Application for a non-material amendment following a grant of planning permission.
Town and Country Planning Act 1990

House:	<input type="text"/>	Suffix:	<input type="text"/>
House name:	<input type="text" value="Plot 474"/>		
Street address:	<input type="text" value="Kingfisher Court"/>		
	<input type="text" value="Wygate Park"/>		
	<input type="text" value="Spaldiing"/>		
Town/City:	<input type="text" value="Spalding"/>		
Postcode:	<input type="text" value="PE11 1AL"/>

We wish to make an amendment to the Eversden plot 474 which replaces a side access door with an obscure ground floor window.

Drawing no: 4026(P6)-EVE-02
Revision: E

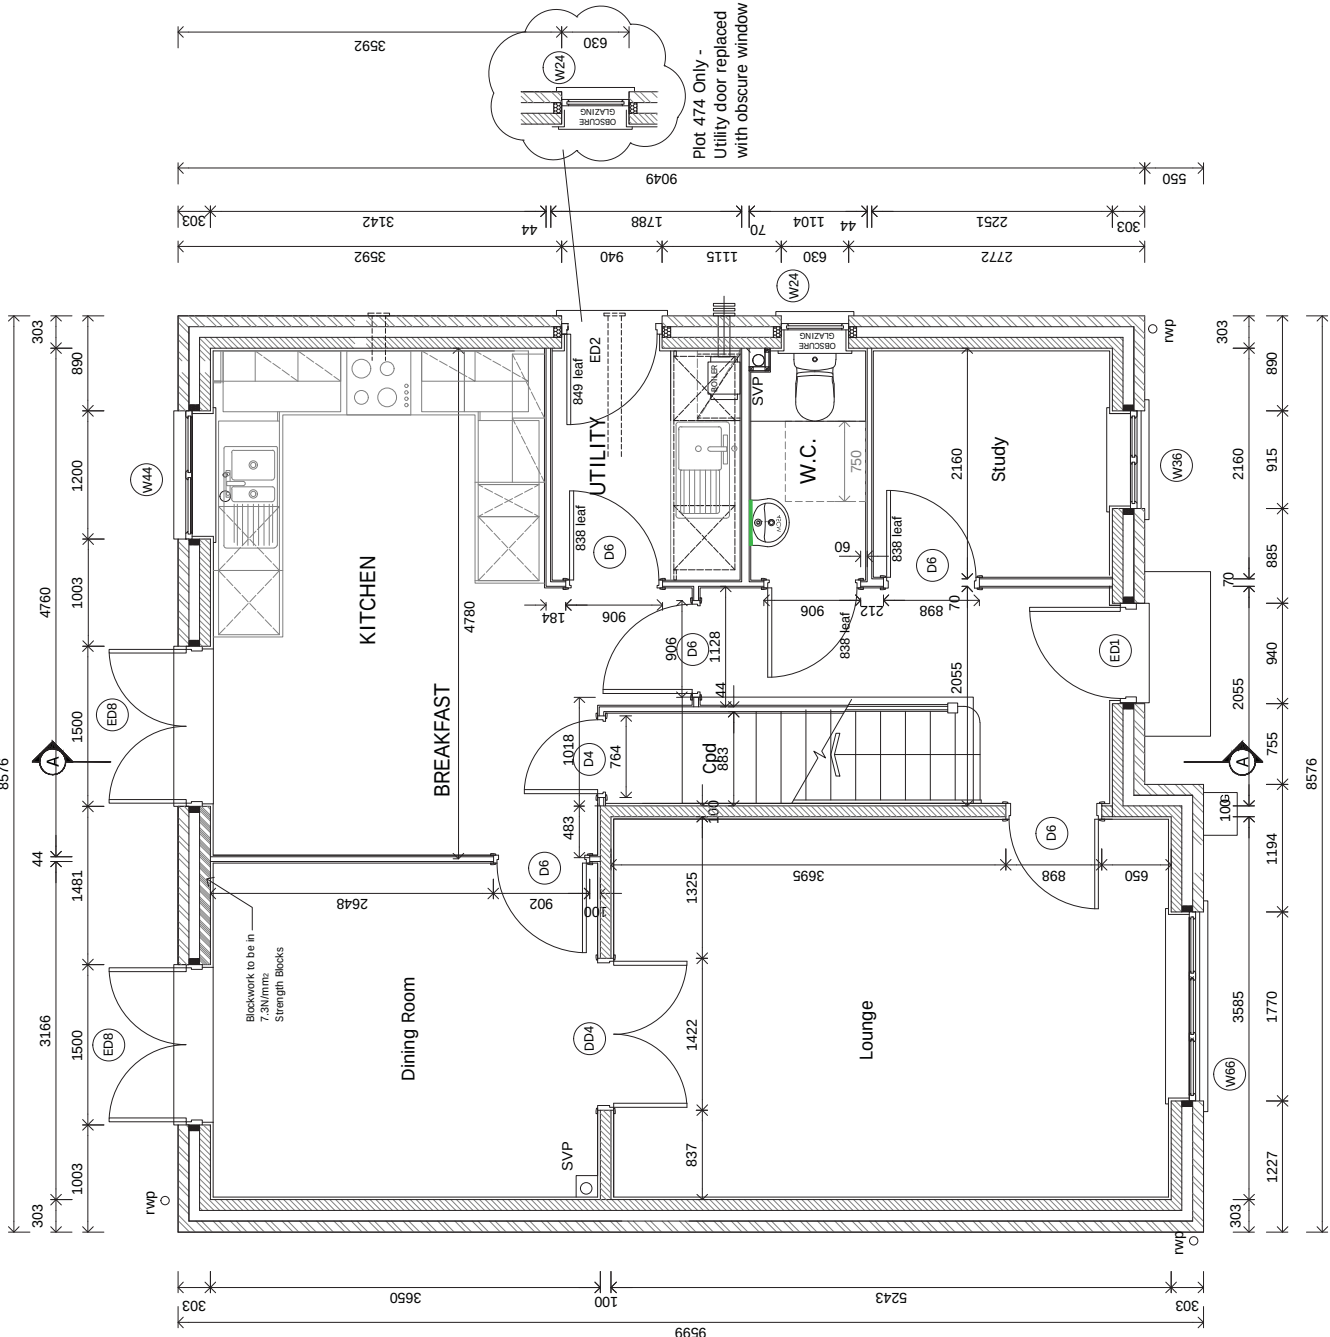
The Eversden plot 474 has been constructed in the approved handing which has resulted in a secondary access door exiting onto third party driveway. Replacing the door with an obscured glass window removes this conflict.
